**Hothersall PC response to Planning Report BKW developments Ltd ref 3/2017/0317**

Applicant: BKW Developments Ltd - Planning Application Number: 3/2017/0317

On behalf of Hothersall Parish Council, I am writing to comment on some of the assertions and subsequent recommendations contained within the Planning Officer's report on this application which will be before committee on Thursday.

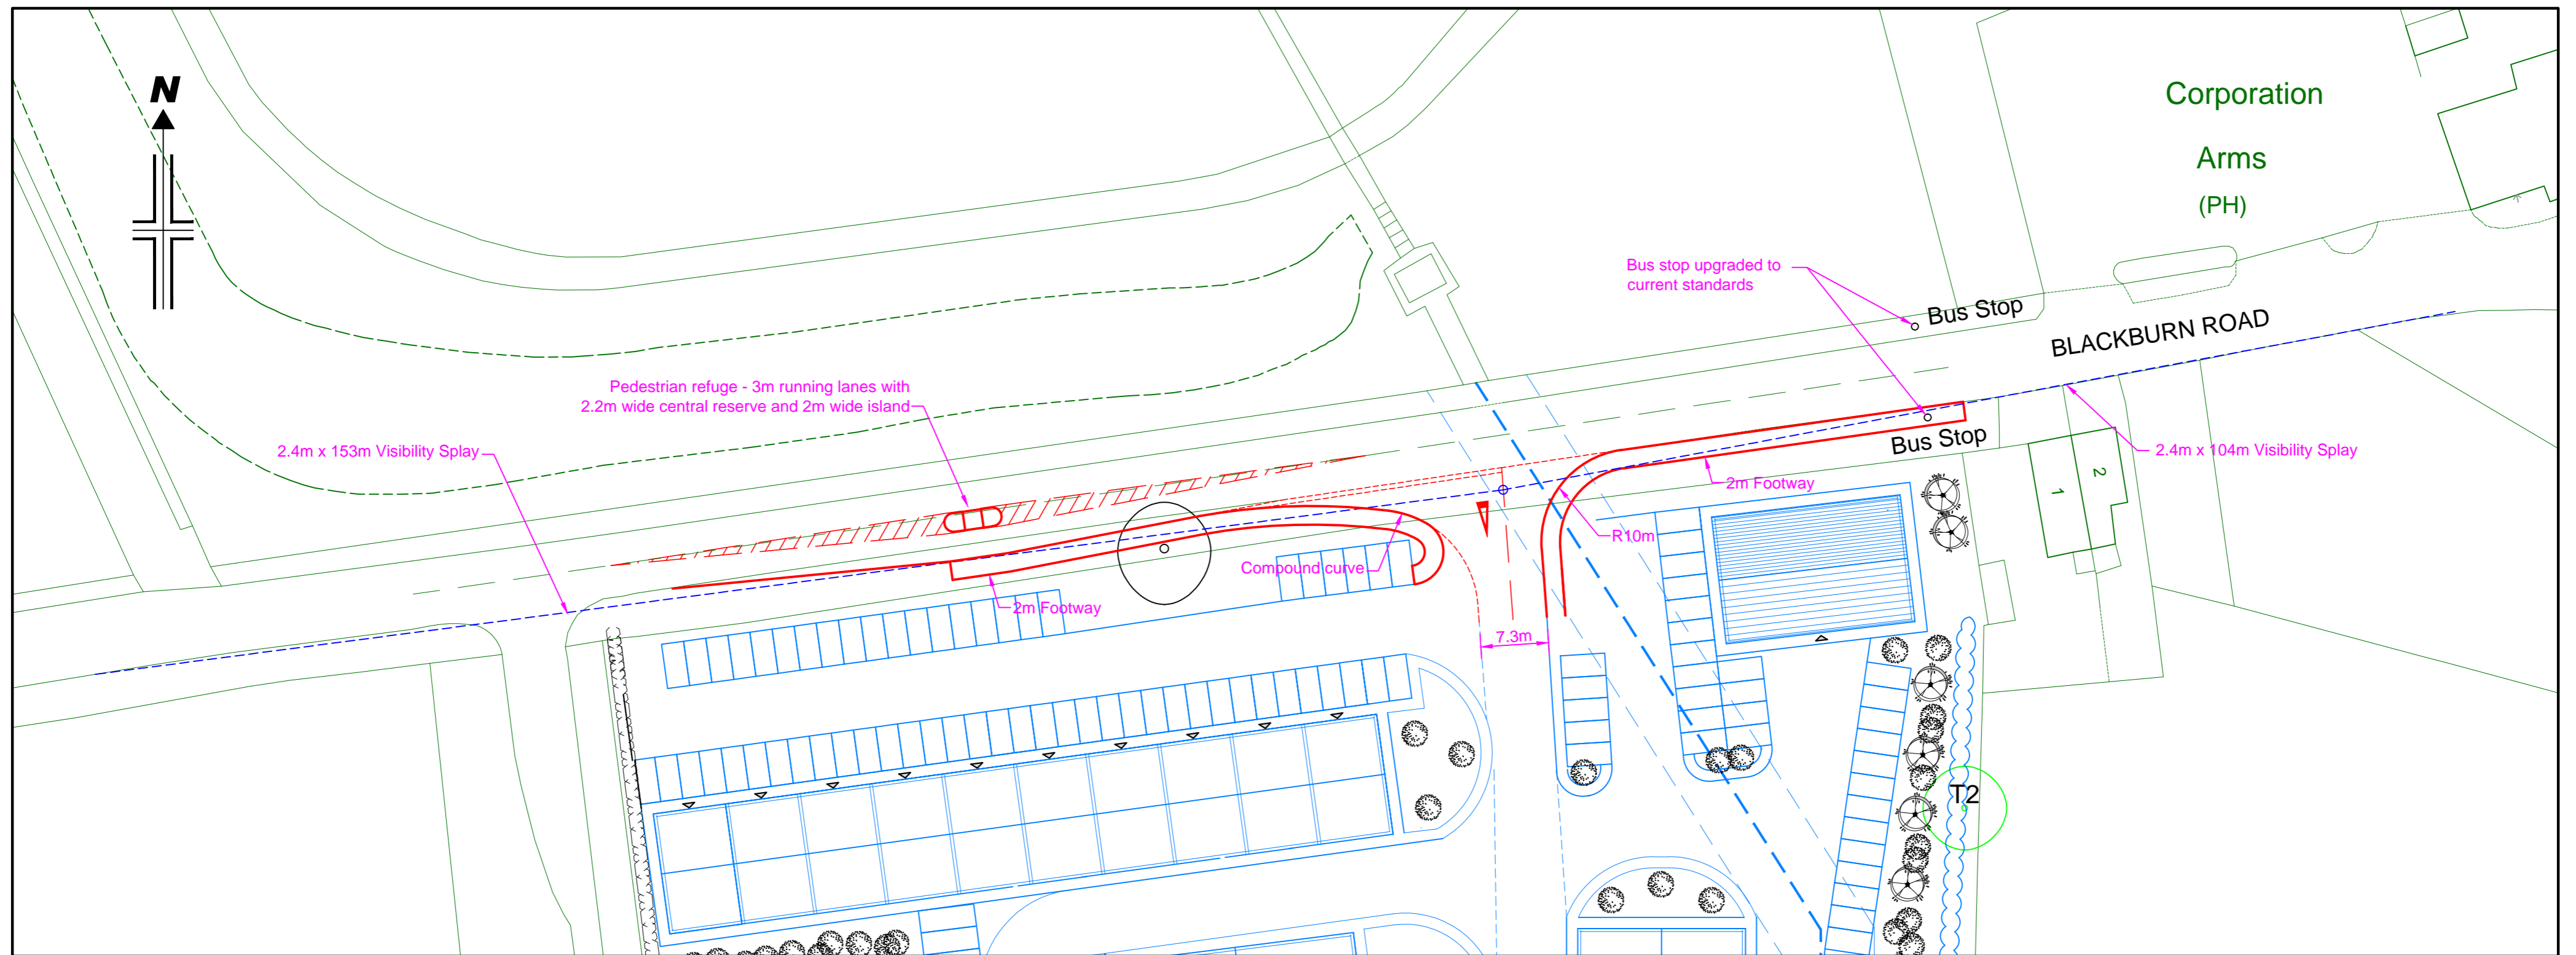
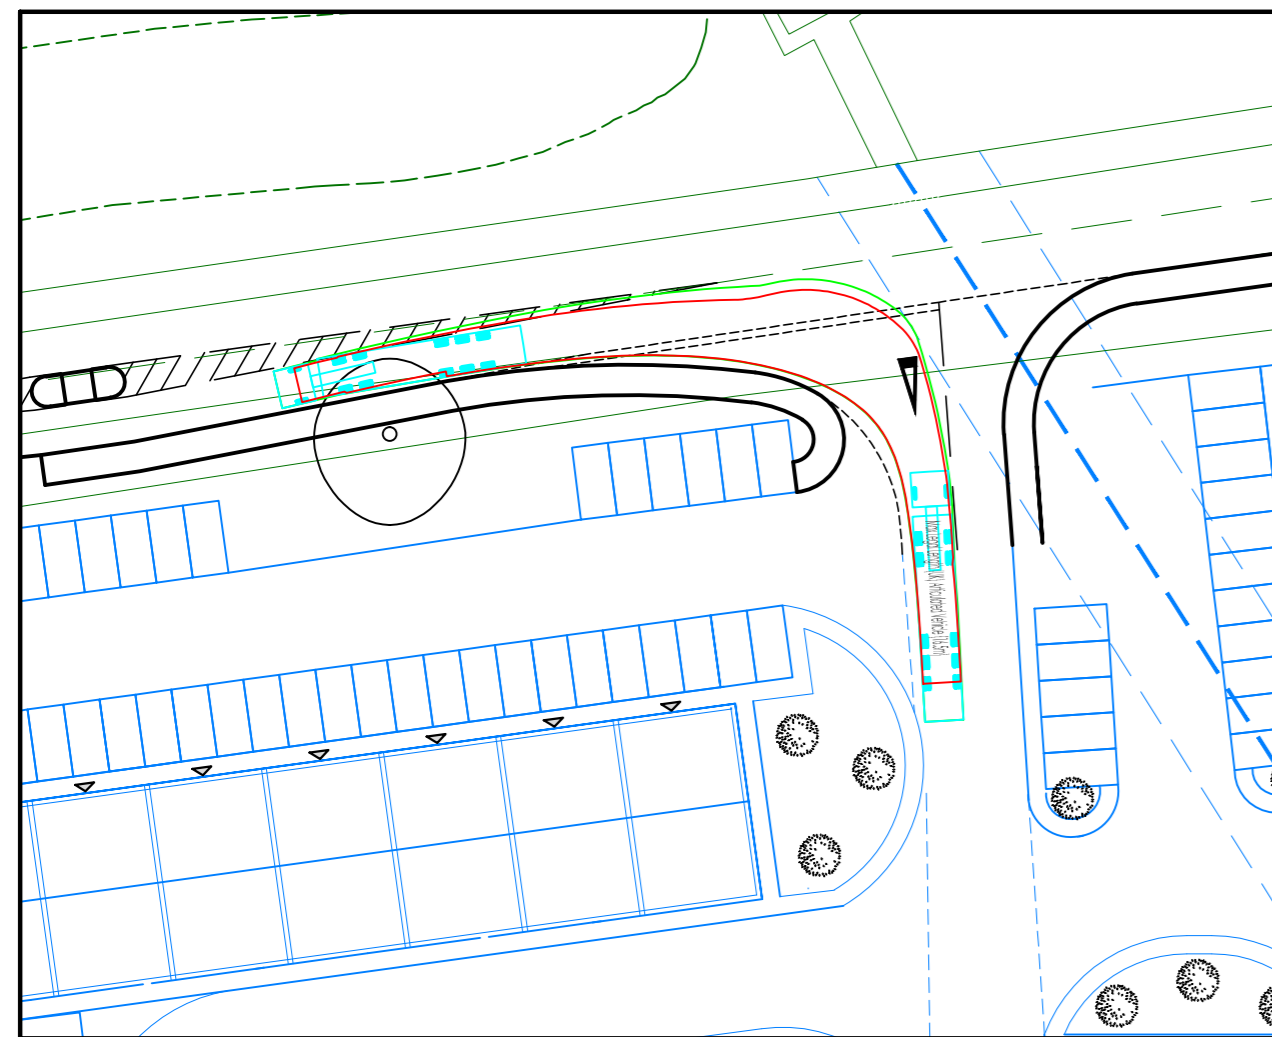
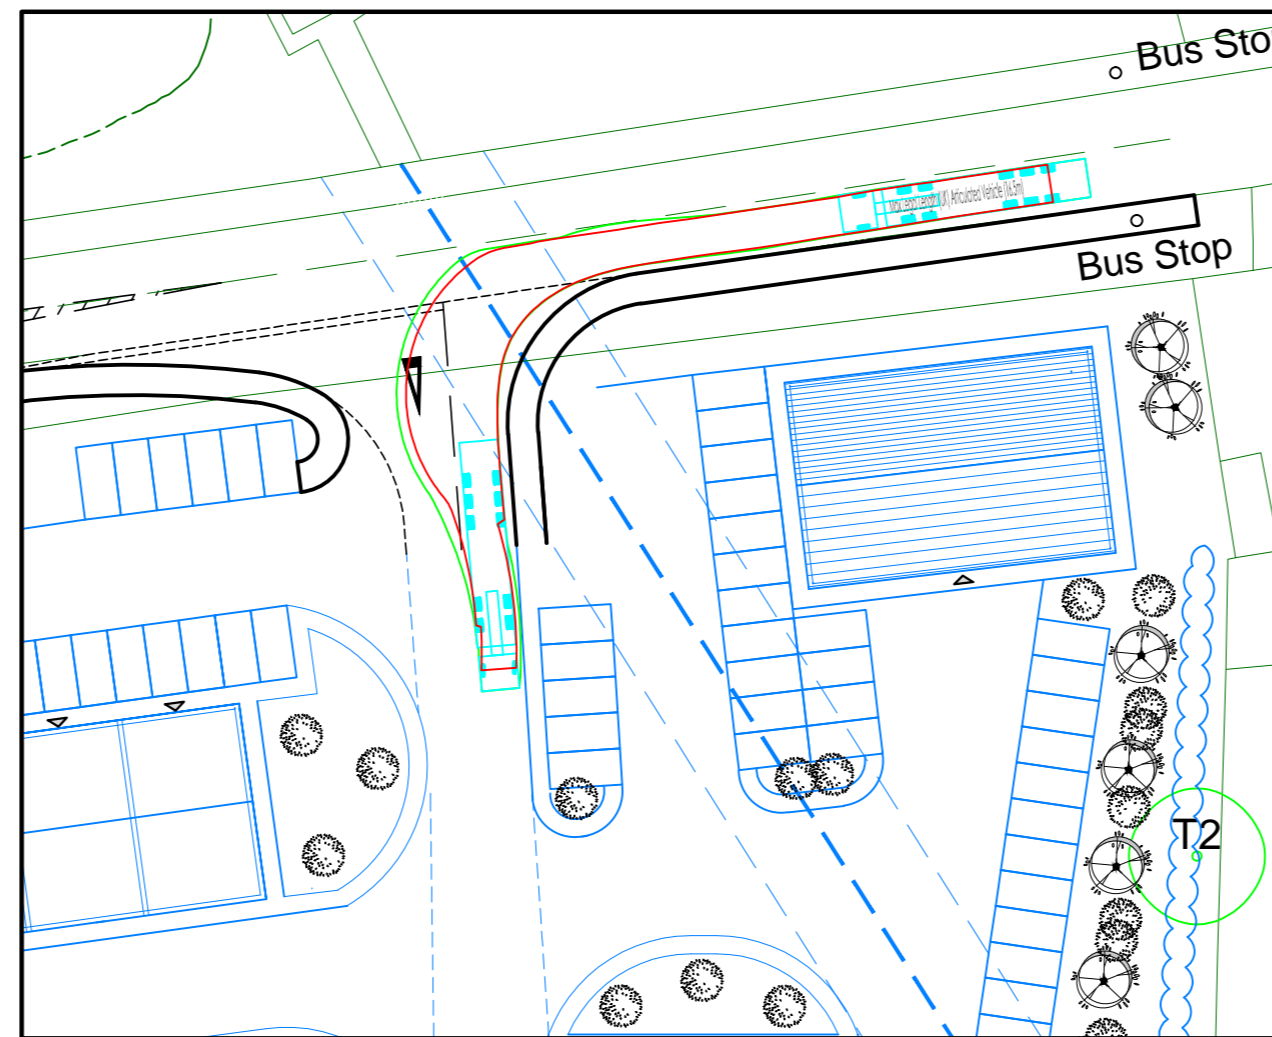
LCC Highways surveyor, Mr Bloomer, recommended refusal of the application given the graveness of his concerns about the site access. We understand that some concerns could be addressed and, in fact, among the late amendments, there are some attempts to deal with the issues raised by the Highways Authority. However (para 5.5.4) significant areas have not been addressed – the practical one of access to an underground pipe and the even more important one of cyclist safety.

Although Mr Birkett asserts that these can be addressed by the applicant, we question BKW's drive to do so given that BKW has failed to do so thus far. Our scepticism is increased by two points (neither noted in the officer's report). The first is that the applicant's Traffic Survey was undertaken during the three day period when Lower Road was closed for resurfacing; the second that his commitment to provide a parking & waiting area for taxis bringing children to Hillside Special School has been withdrawn following the opposition of the school Governors to this application.
